Your Ref: OWPC21957
Our Ref: AB/21/19/T
Please ask for:
Mr Z Denton

Fell to ground level 1No. Goat Willow tree and 2No. Sycamore trees. Crown lift to 3m
2No. Sycamore trees.

Electricity Sub Station Land adjacent to 1 Ford Road Arundel

Site Plan

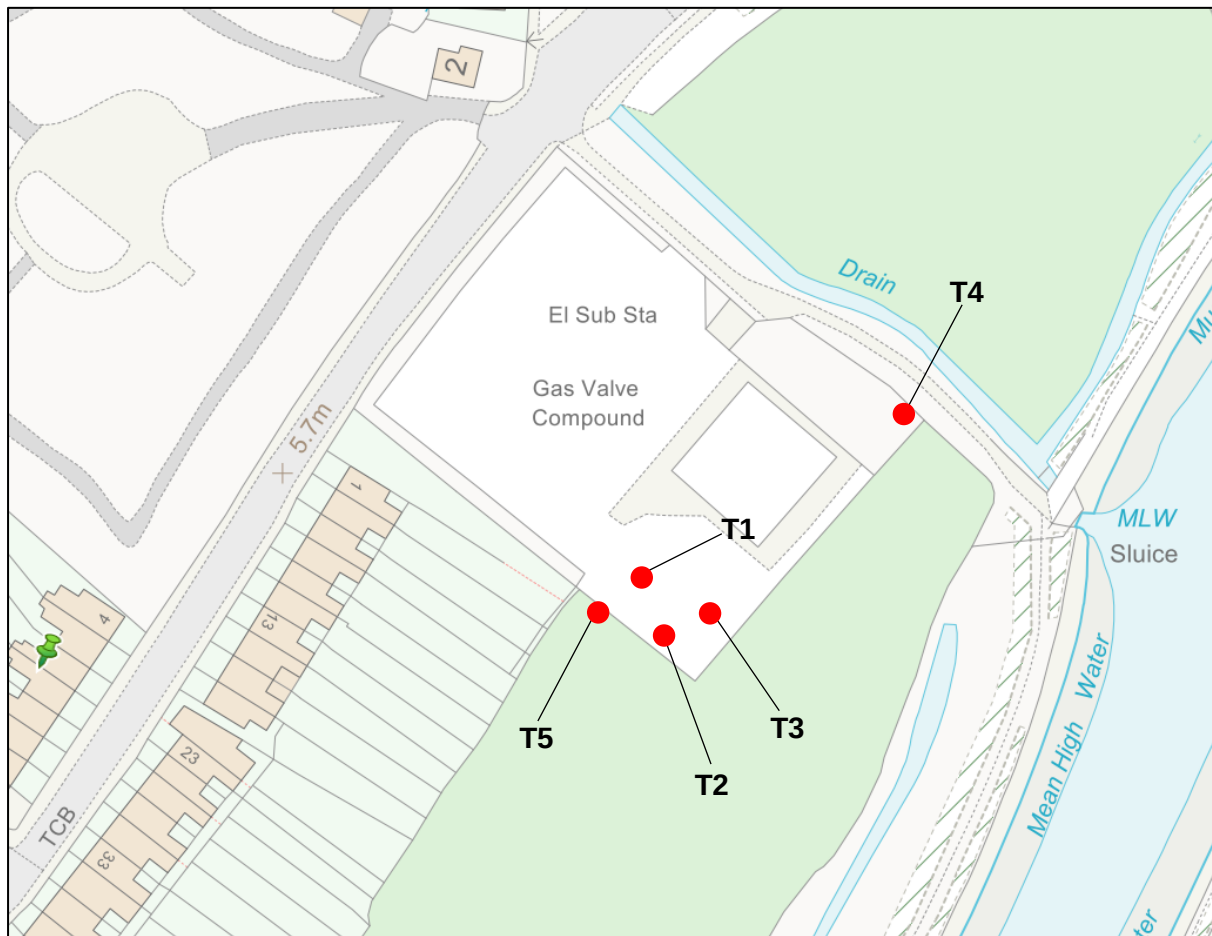
The Committee objected to the application as there was no evidence from neighbouring residents that the Oak tree (T3) resulted in excessive overshadowing or that there was any other justification to fell other healthy trees on the site in a Conservation Area. Furthermore, some of the details provided in the application form were incorrect and rendered the application potentially invalid.
